Re: Variation to Impacts on Aboriginal Heritage at Sturt Highway to Tarcutta (N1), Kyeamba Hill (N2) and Little Billabong (N3).

I refer to your letters of 28 August 2007 and 10 September 2007 regarding the Hume Highway Duplication Project and proposed variations to impacts on Aboriginal Heritage along the Sturt Highway to Tarcutta, Kyeamba Hill and Little Billabong sections.

<b>NORTHERN HUME ALLIANCE</b>		
N2 - KYEAMBA HILL ENVIRONMENTAL CONSTRAINTS PLAN		
STATUS: DETAILED DESIGN	DRAWING NO: NHA-EN-22192013	REV: 01
		SHEET 13

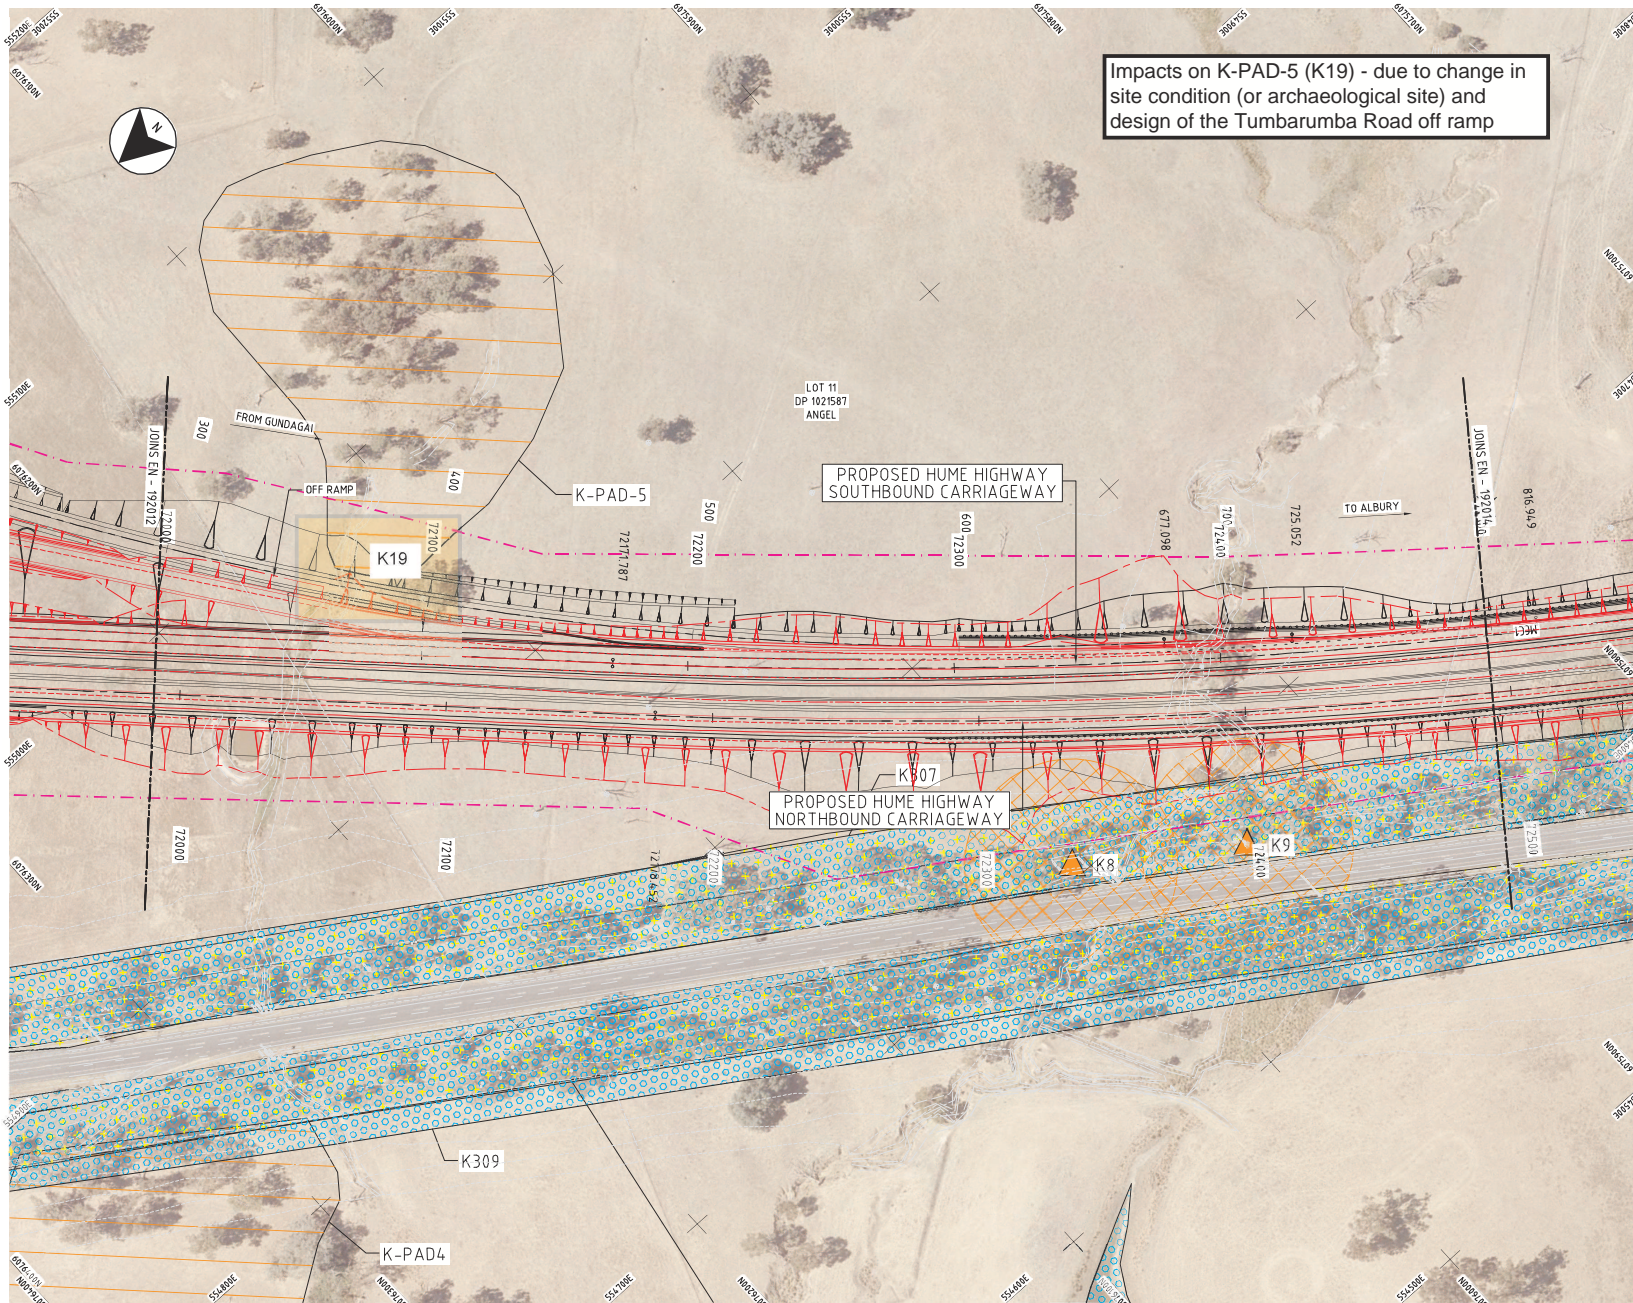
- K-PAD-5 - As a small area of this site will now be impacted by construction activities, DECC endorse the proposed mitigation measure of a surface collection of the recently located artefacts. The surface collection should be restricted to those areas of the site that exist within the construction corridor. The surface collection should be undertaken in accordance with the methodology described in Appendix C of the document *Hume Highway Upgrade*
